**WEST SUSSEX COUNTY COUNCIL
PLANNING SERVICES CONSULTATION**

SUBJECT: BR/161/17/PD - Notification for prior approval under Part O for change of use from office (ClassB1(a)) to 14 No. residential apartments (Class C3).

6, York Road Chambers, Bognor Regis, West Sussex, PO21 1LT

DRAWING TITLE
CONVERSION OF OFFICES TO
RESIDENTIAL
PROPOSED FIRST FLOOR PLAN

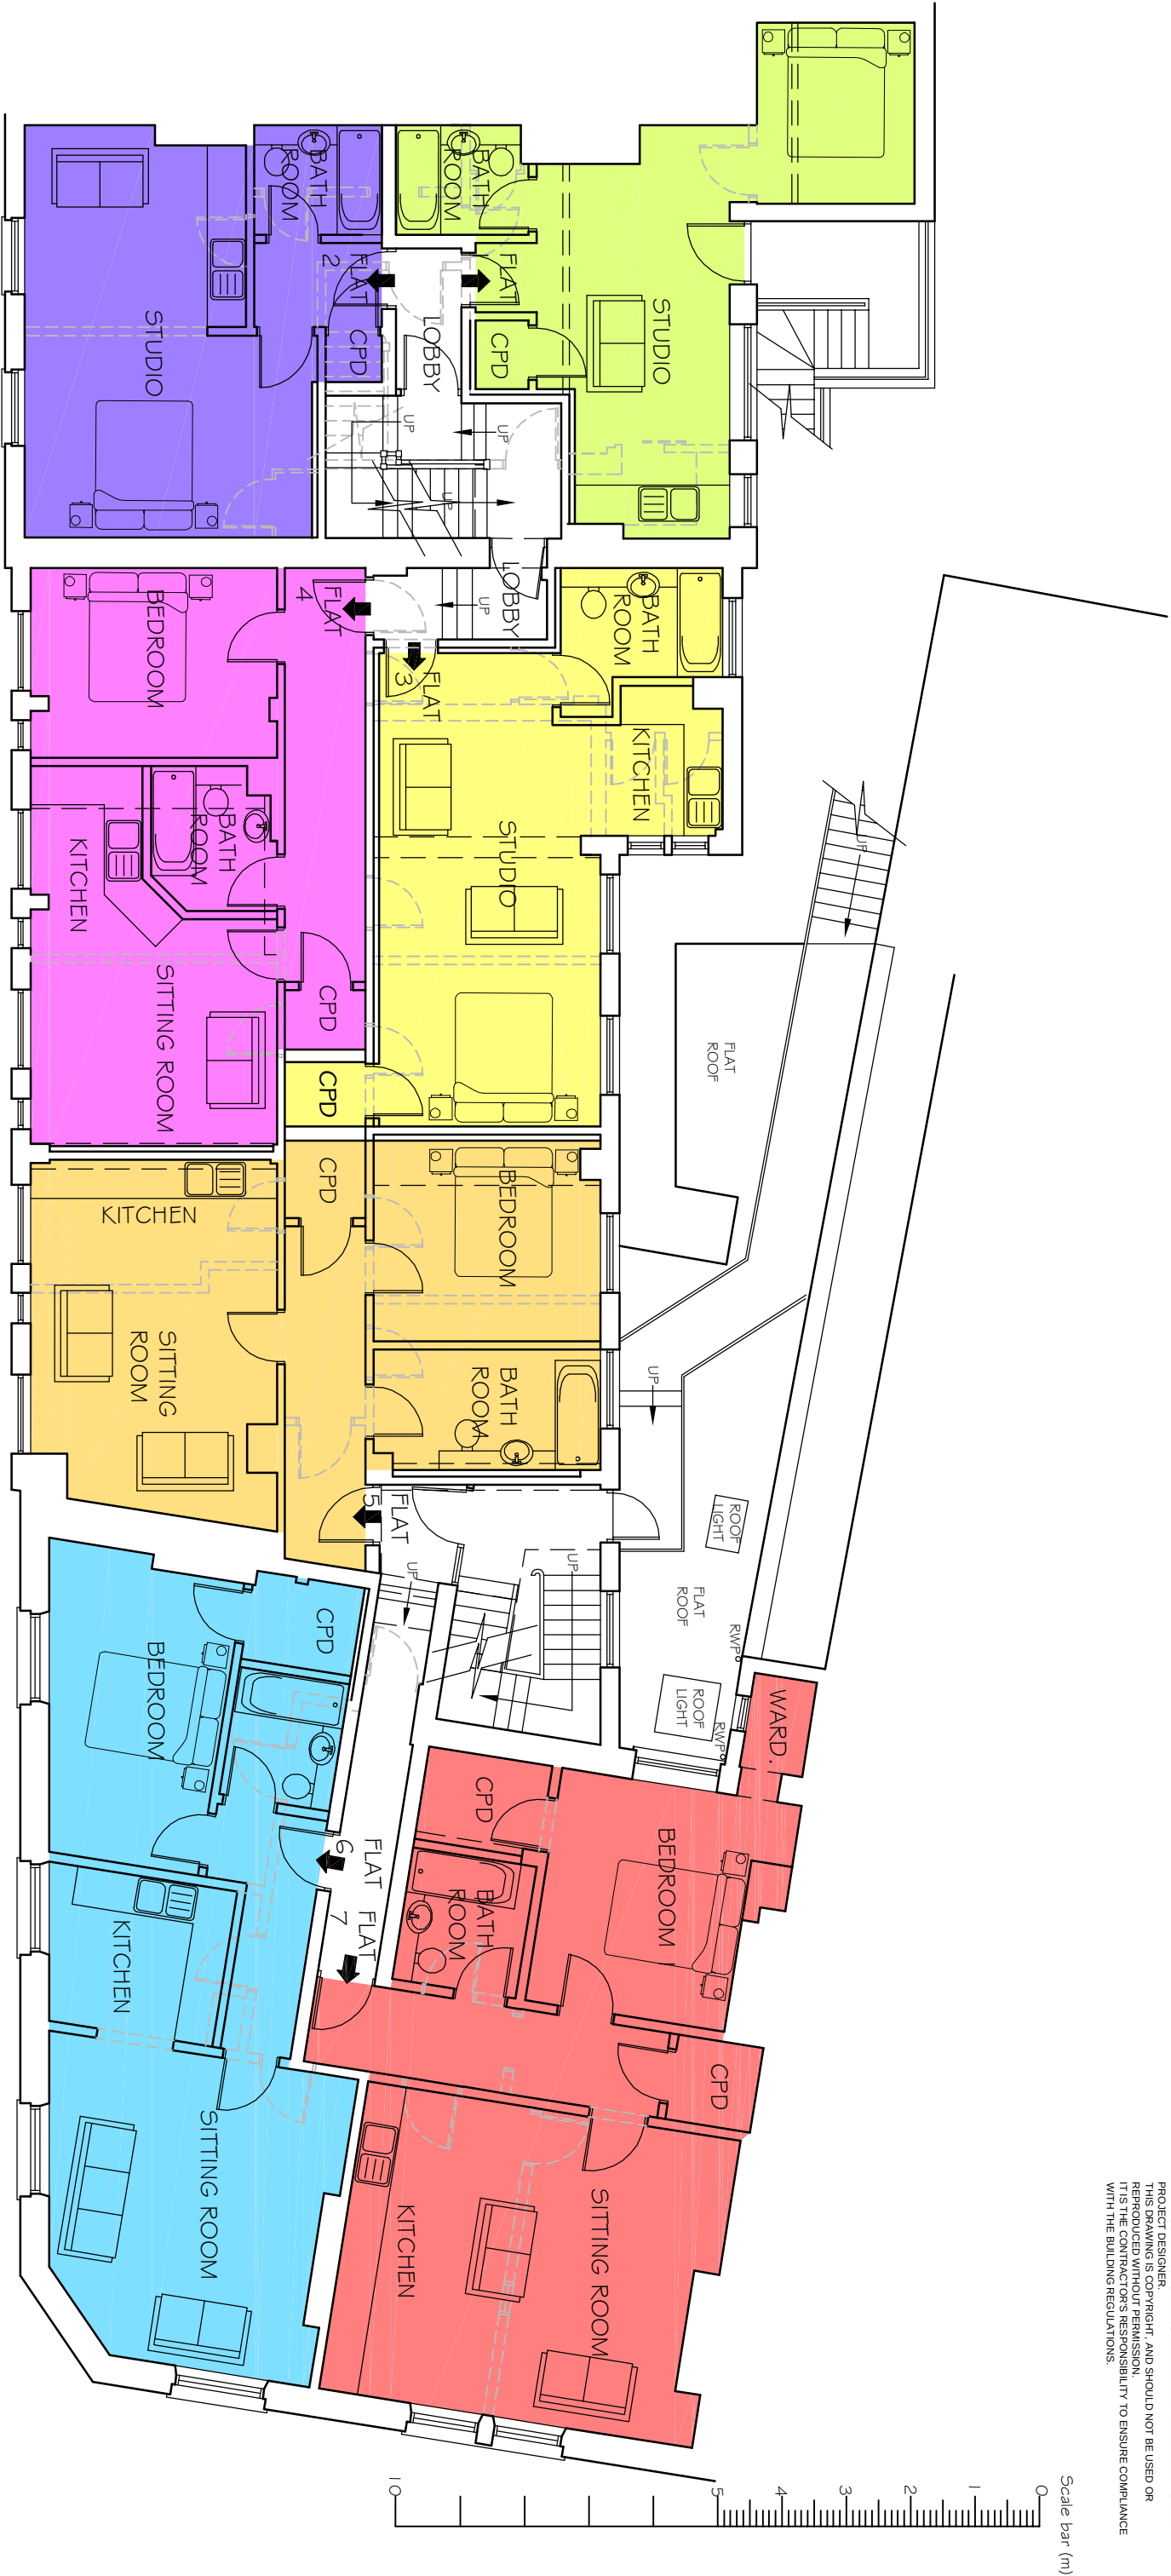
No cycle parking is indicated on the proposed floor plan. Cycle parking should be provided in line with WSCC standards which would equate to 7 spaces within communal storage.

No part of the development shall be first occupied until covered and secure cycle parking spaces have been provided in accordance with plans and details submitted to and approved by the Local Planning Authority.
